**DELEGATED DECISION FOR APPLICATION FOR CERTIFICATE OF  
LAWFUL DEVELOPMENT**

Reference no.: 2024/CL/93043/E

Site: 85, Hartshead Lane, Hartshead, Liversedge, WF15  
8AL

Description: Certificate of lawfulness for proposed erection of  
single storey side extensions, outbuilding and front porch

Drawing: **PROPOSED SITE PLAN.**

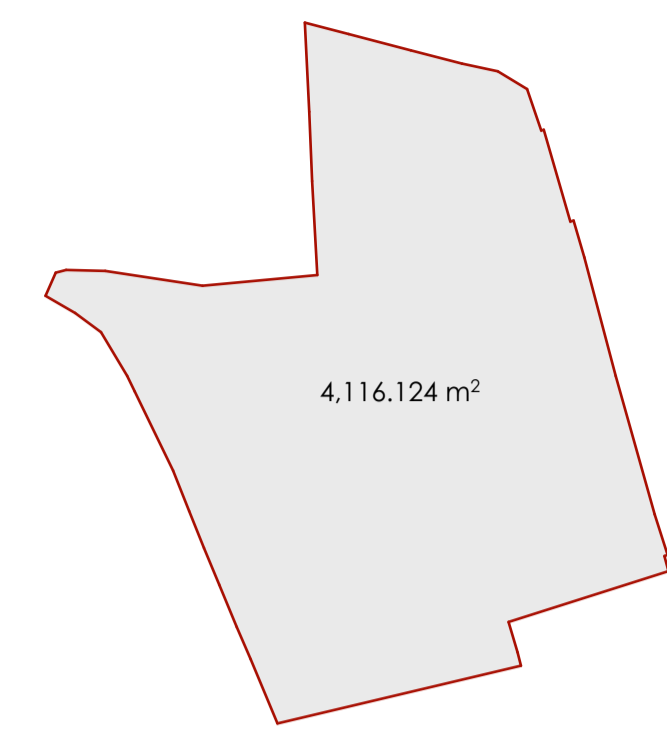
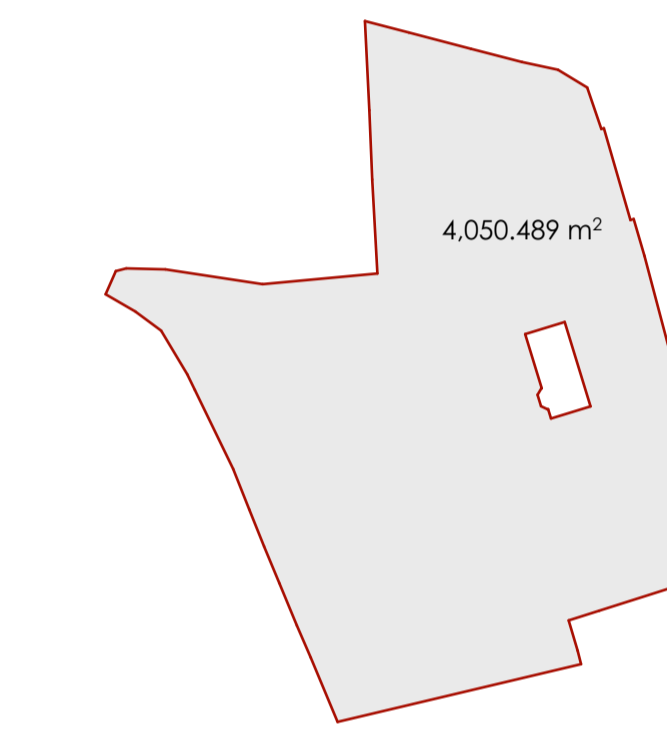
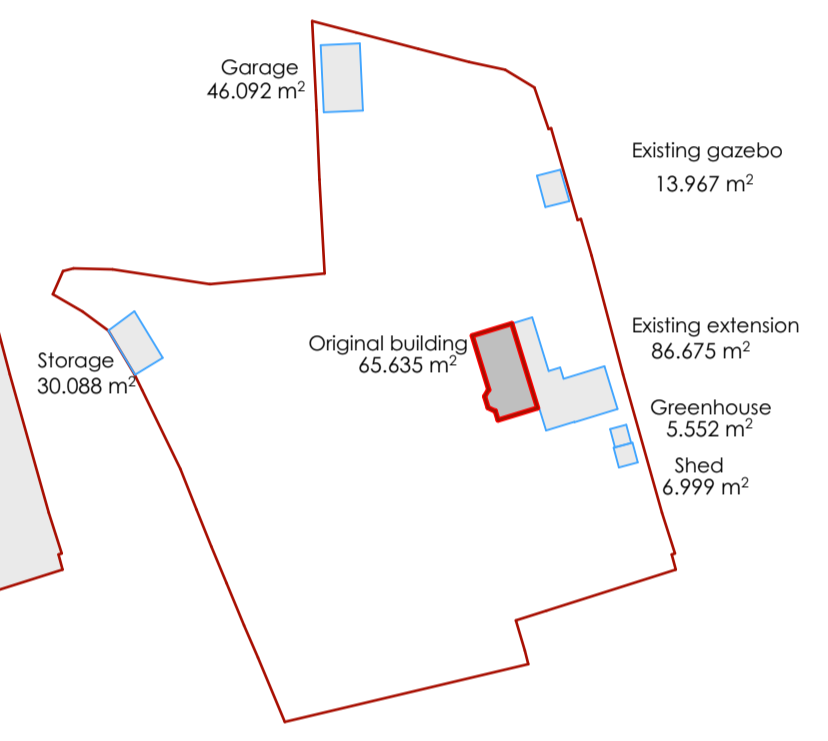
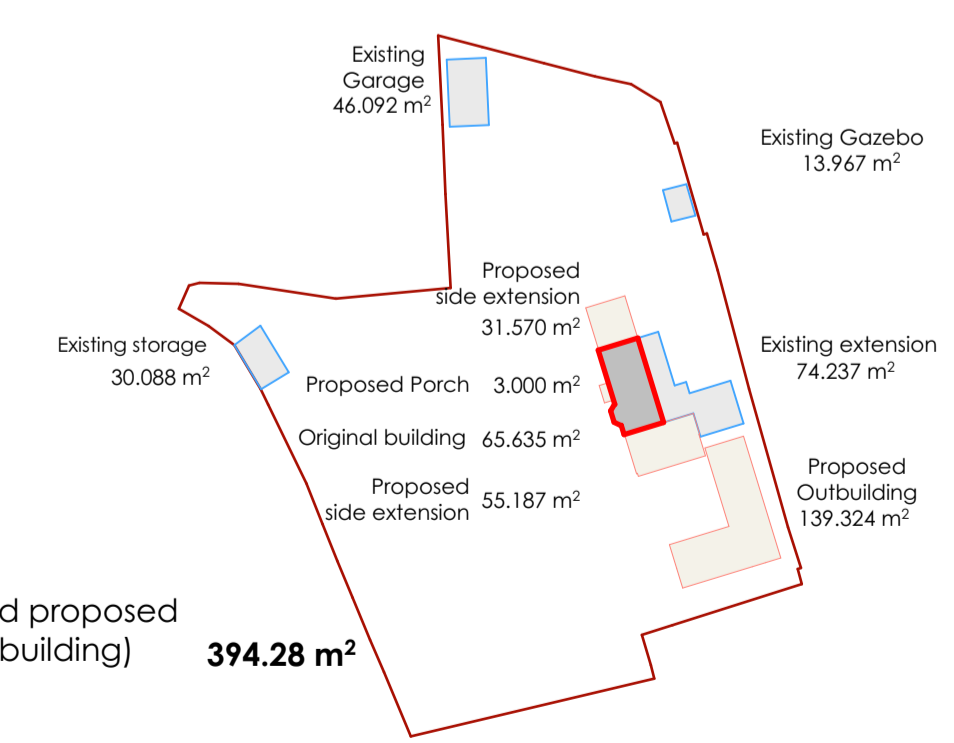
***Comment:*** *The total area of ground covered by the proposed works including the proposed extensions, outbuilding and porch in addition to the existing extensions within the site would exceed 50% of the ground covered.*

**Comment:** The total area of ground covered by the proposed works including the proposed extensions, outbuilding and porch in addition to the existing extensions within the site would exceed 50% of the ground covered.

However, plan reference 01\_00 R03 submitted as an amended plan on 7<sup>th</sup> October 2025 states that the original building was 65.635 square metres and the proposed outbuilding would be 139.3224 square metres. Therefore, notwithstanding the proposed side extensions and the existing extensions to the property, the outbuilding alone would increase the footprint of the property over and above the original footprint by 212%. This appears excessively large to constitute being reasonably incidental to the enjoyment of the dwellinghouse.

02_01 Ground Floor 1:100

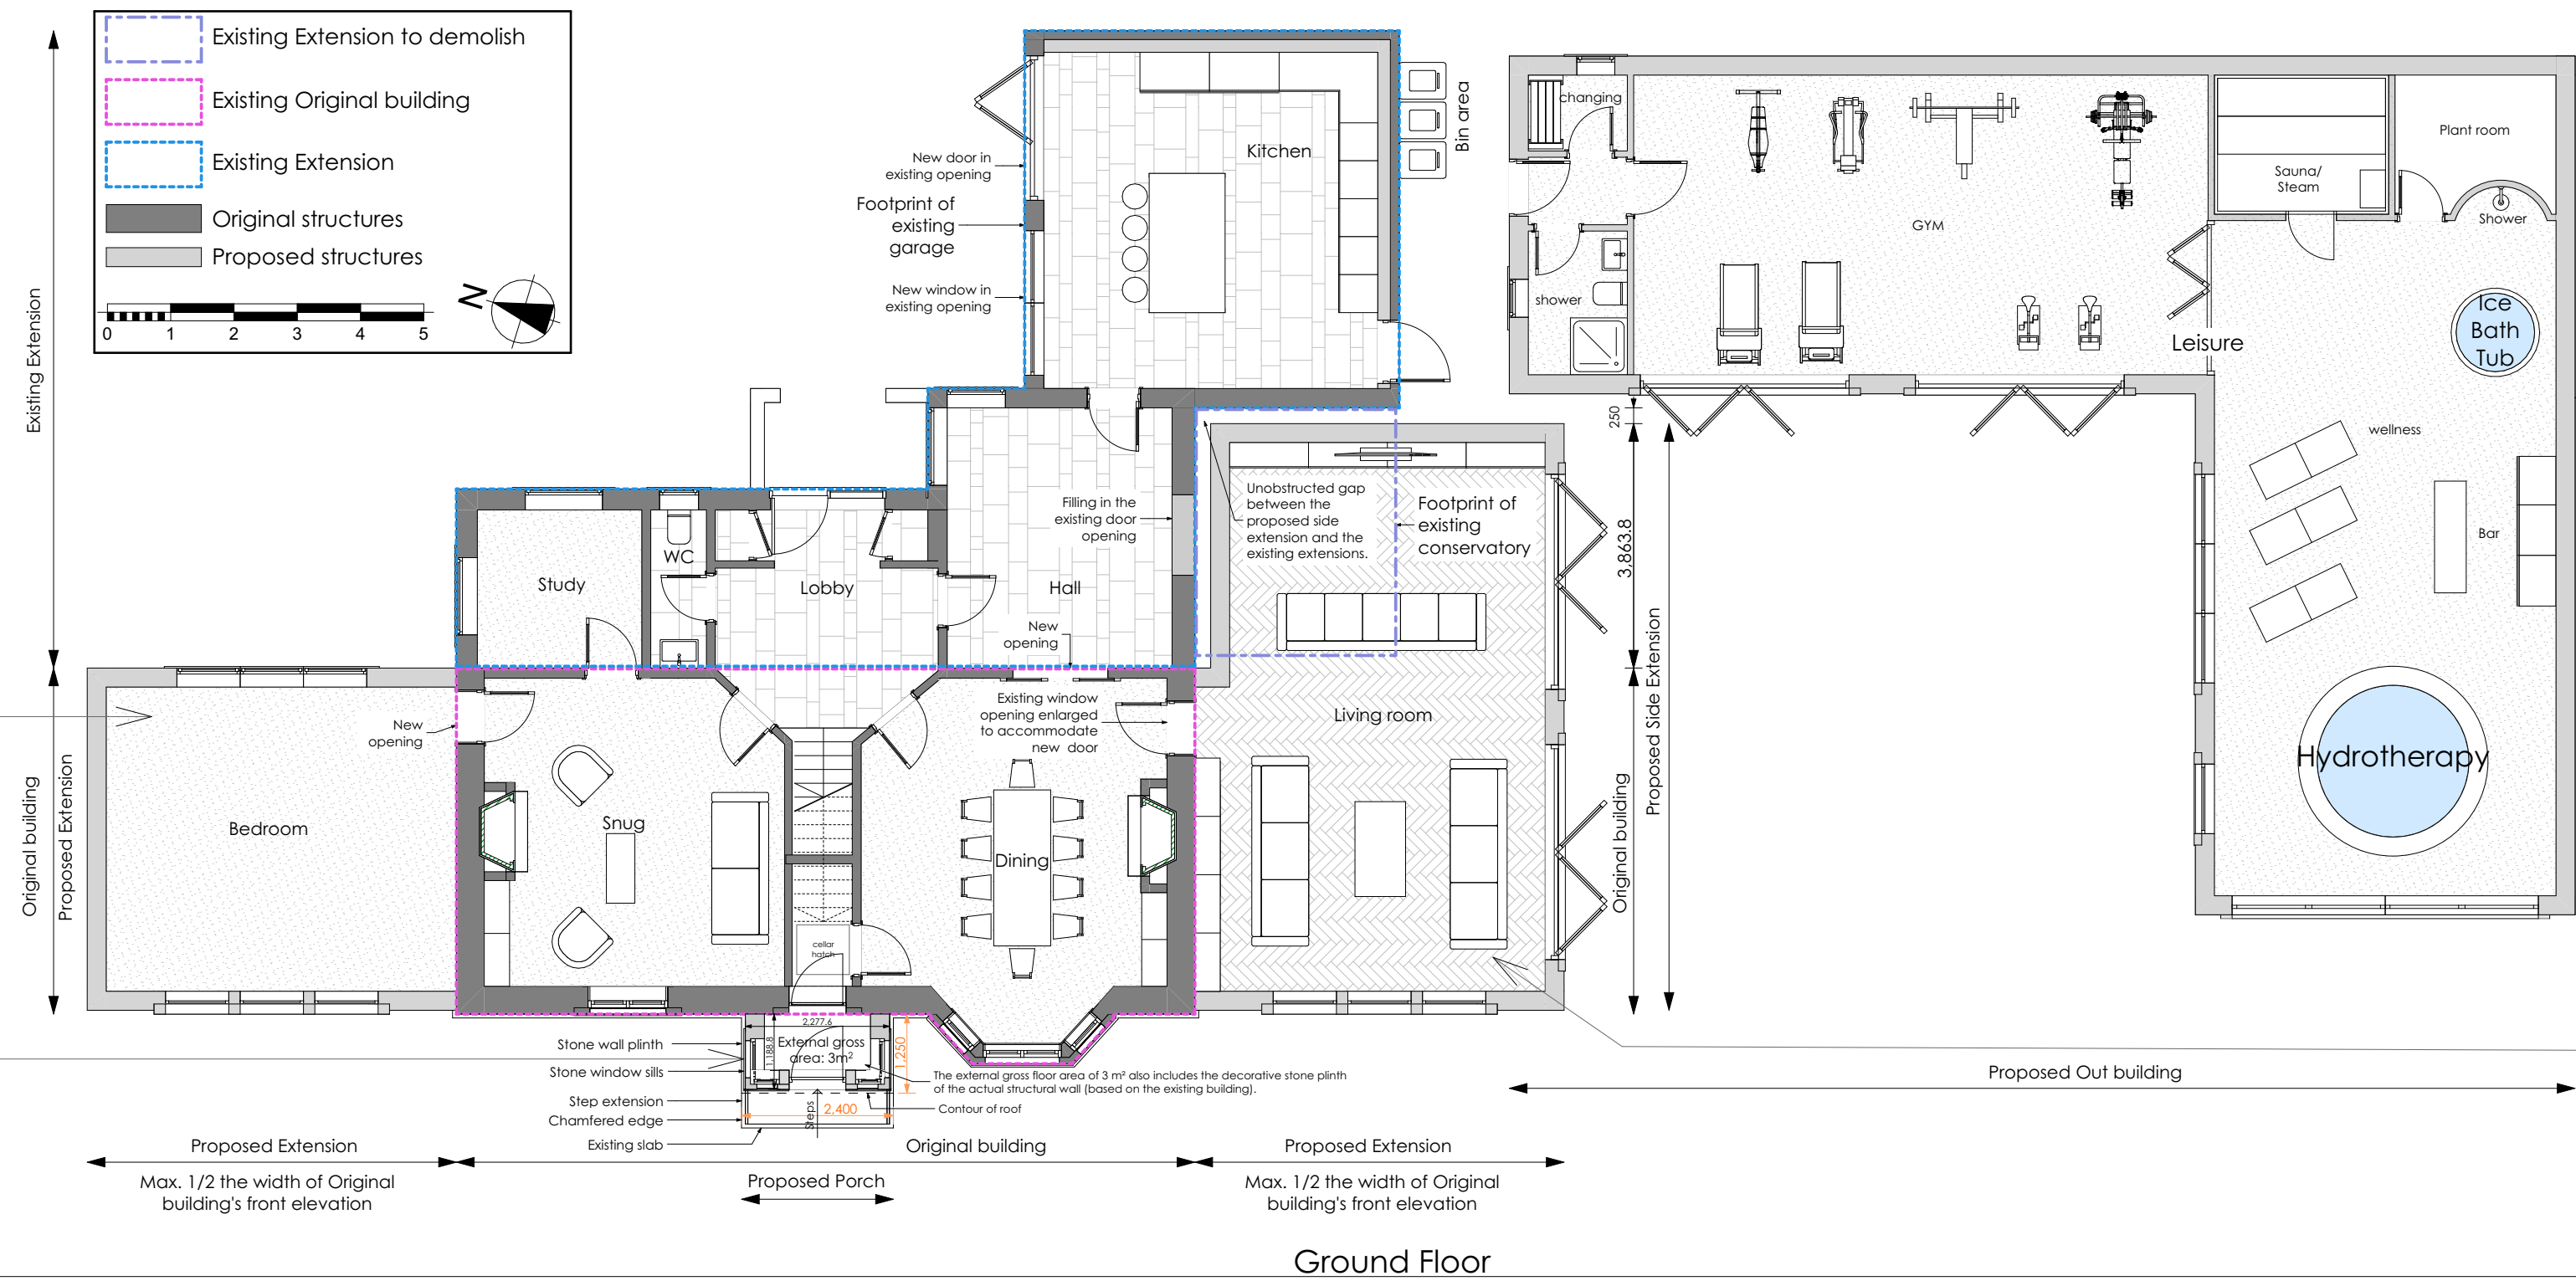
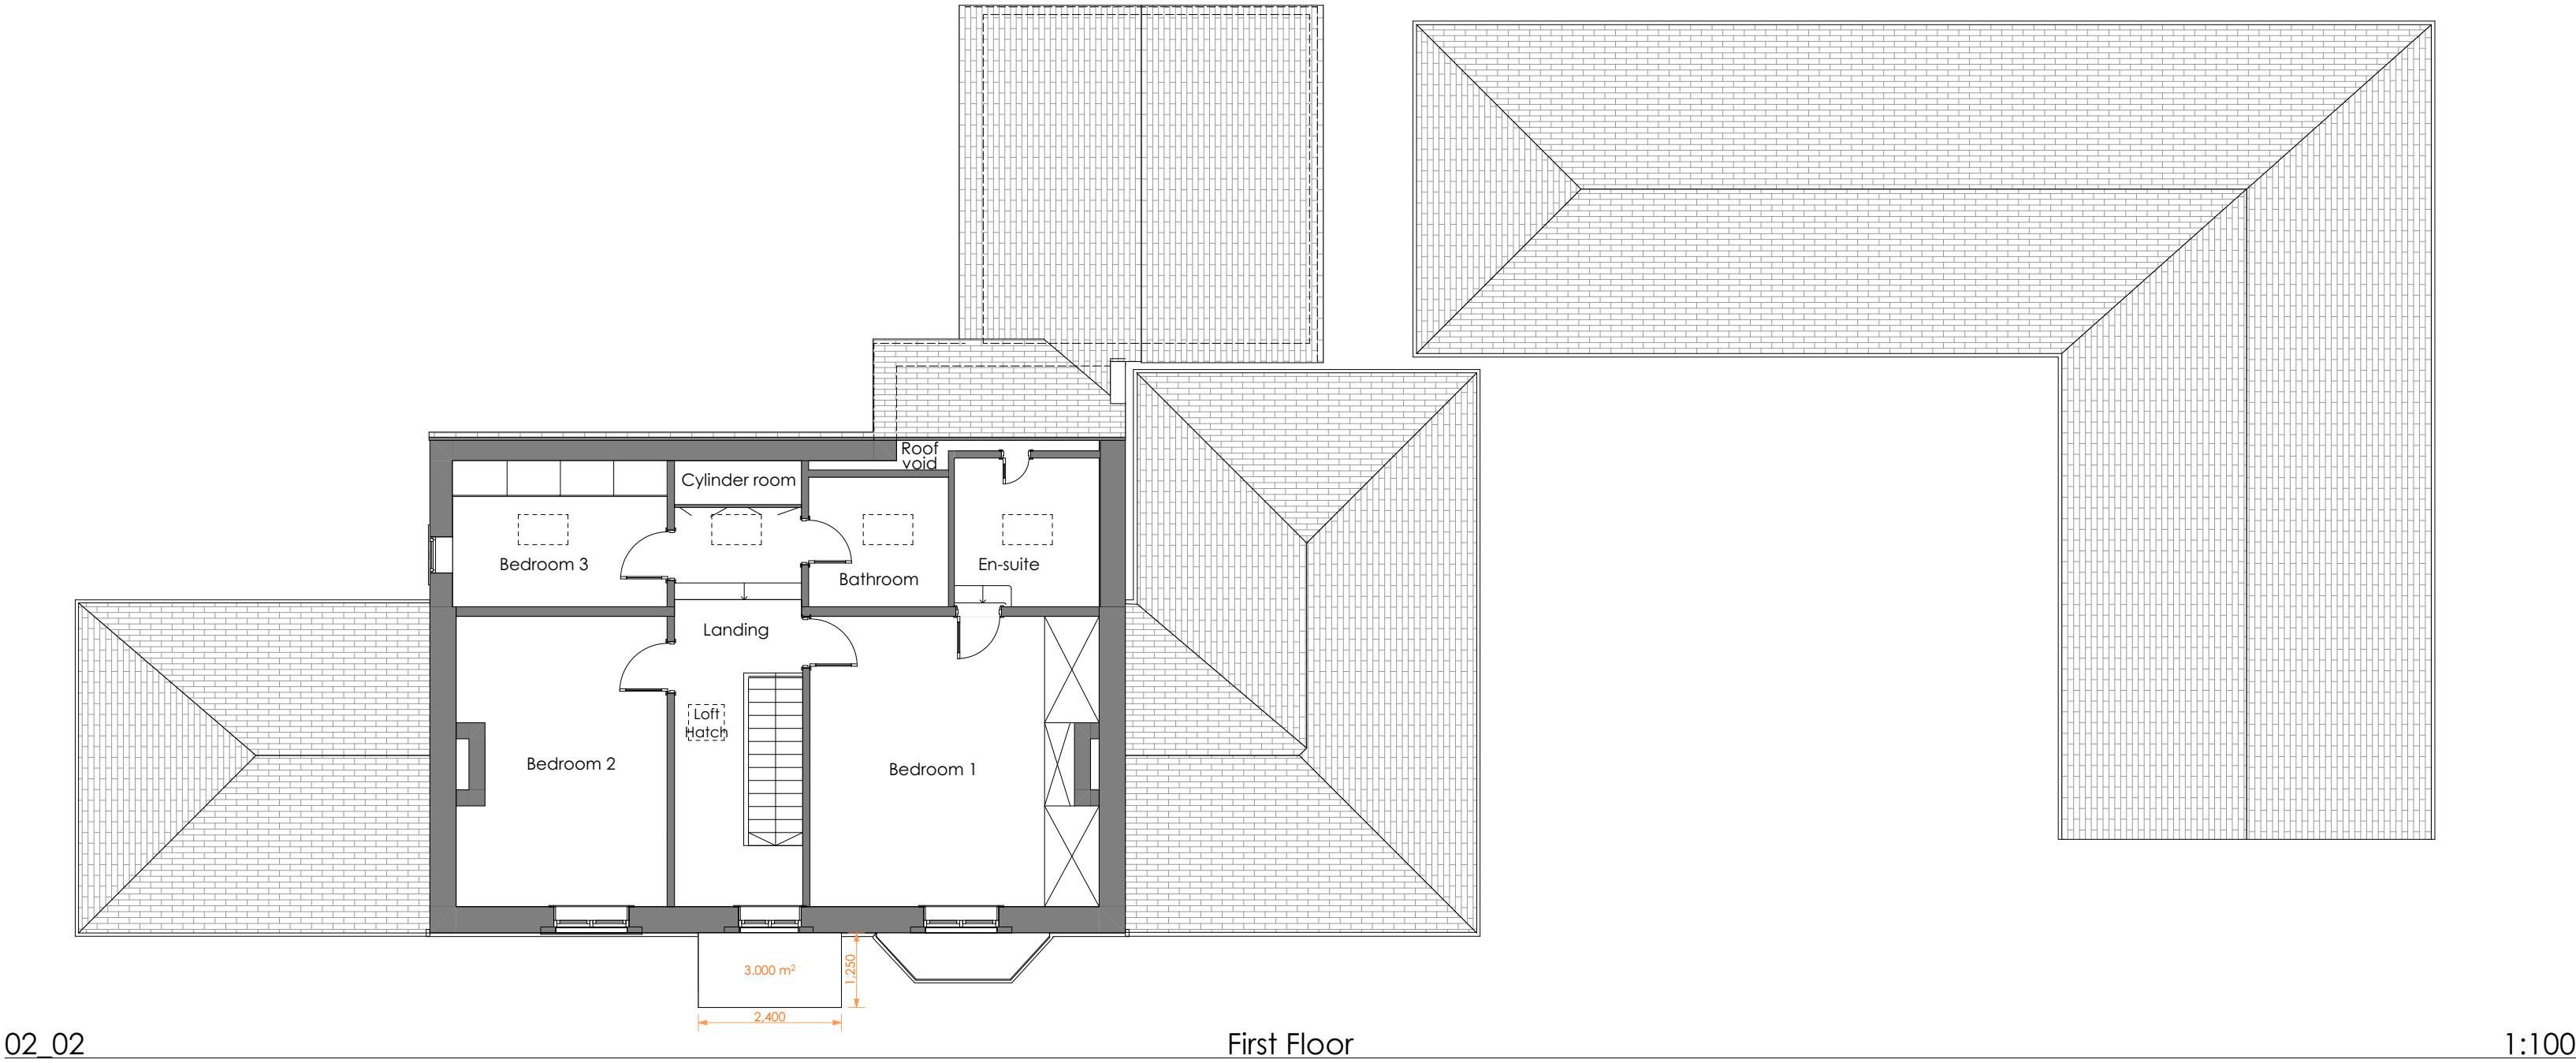
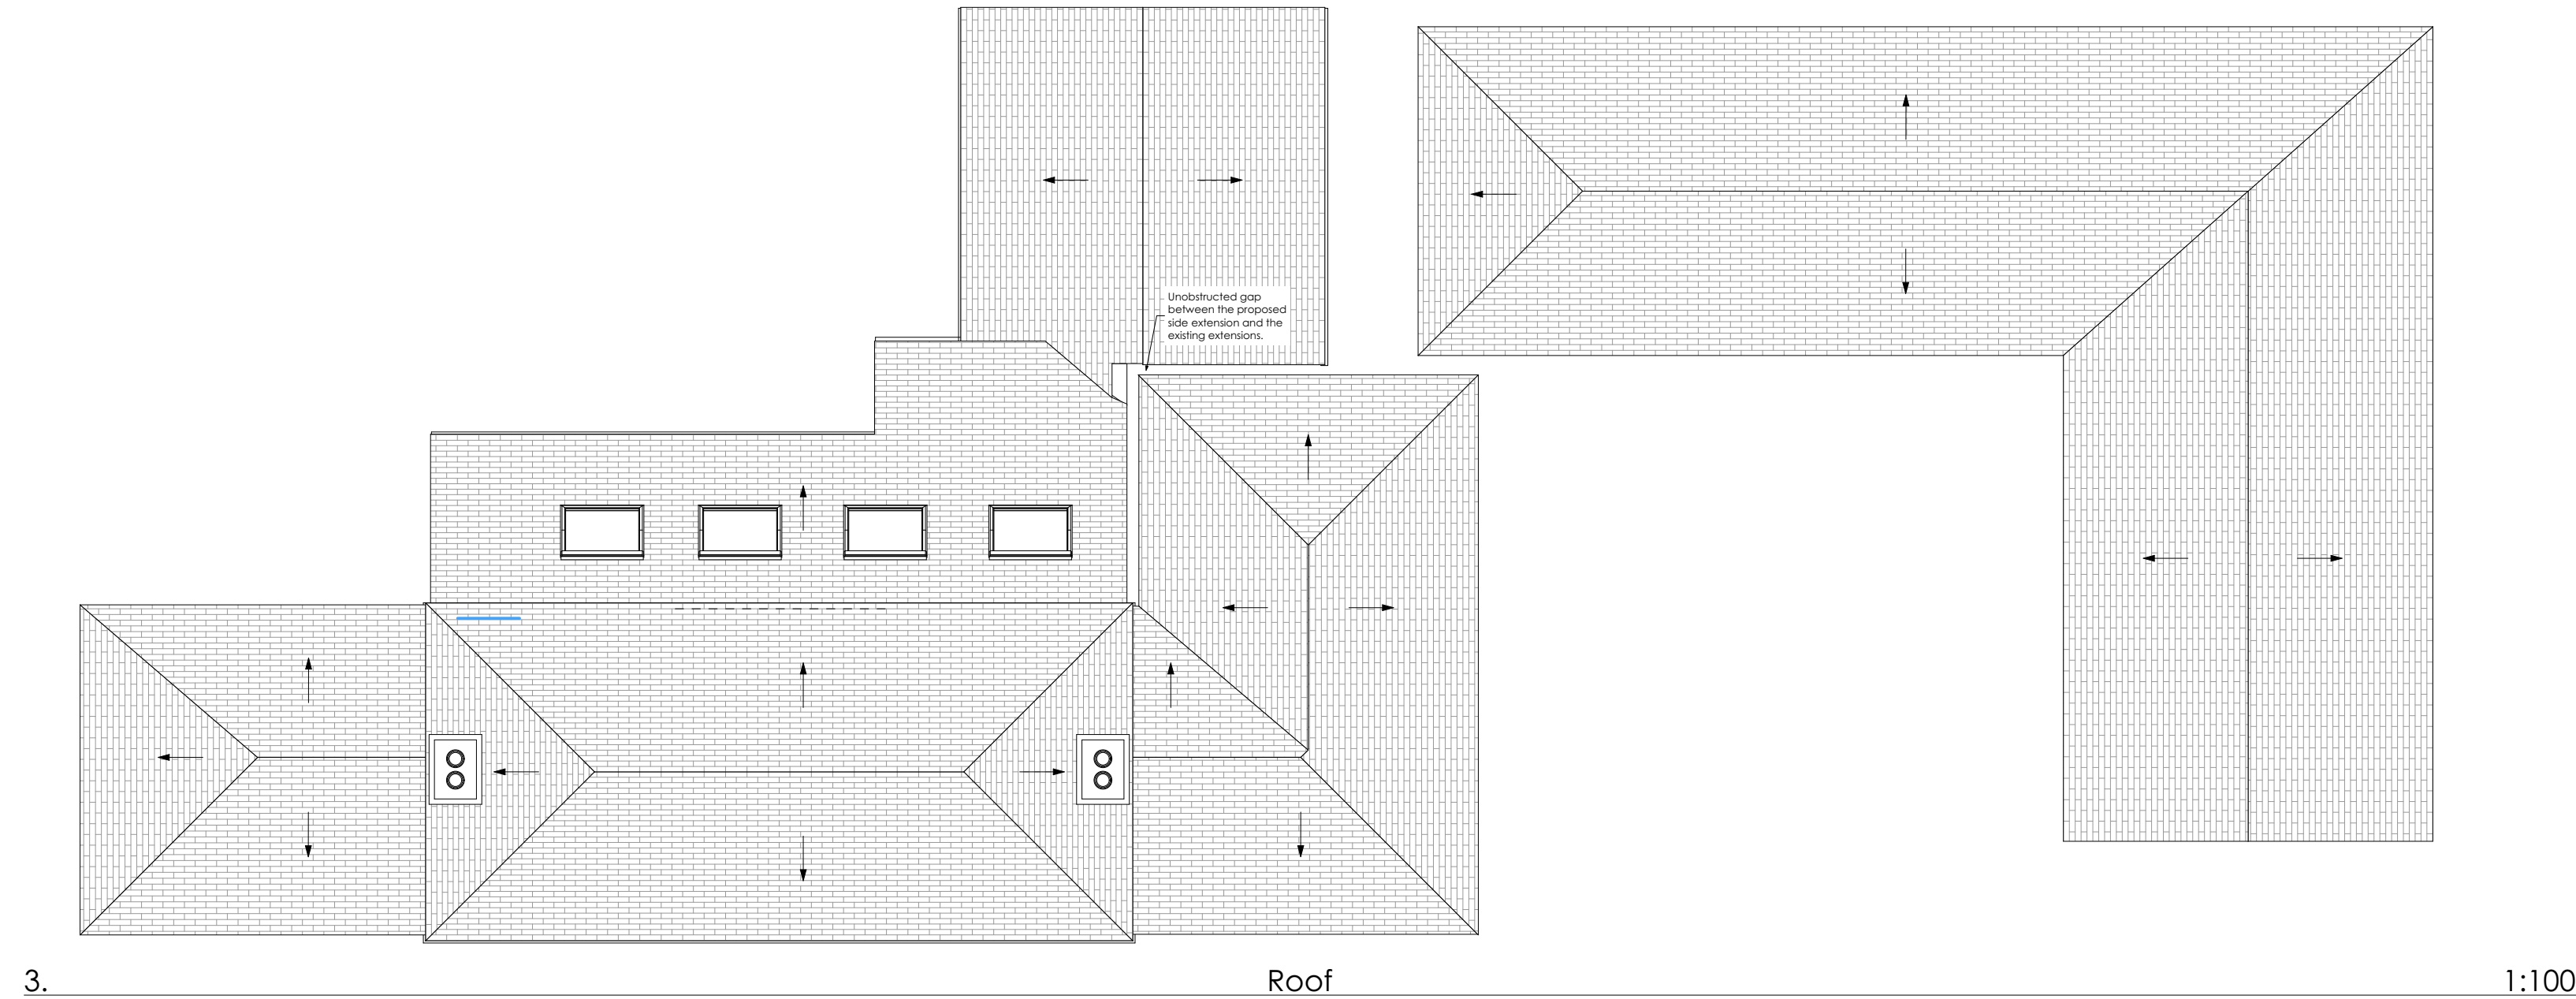
The plans are annotated to demonstrate that the outbuilding would be used for ‘leisure’ which would include a hydrotherapy pool, bar, wellness area, ice bath tub, sauna/steam room, plant room, shower room, changing room and gym.

Whilst health care needs can provide justification for the size, layout and use of outbuildings, no evidence has been submitted to demonstrate how the calculations of the space requirements have been formulated and there is no evidence from health professionals in support of such a large building for the incidental use of the applicants.

It cannot therefore be concluded that all the space within the building is reasonably required for purposes incidental to the enjoyment of the dwellinghouse.
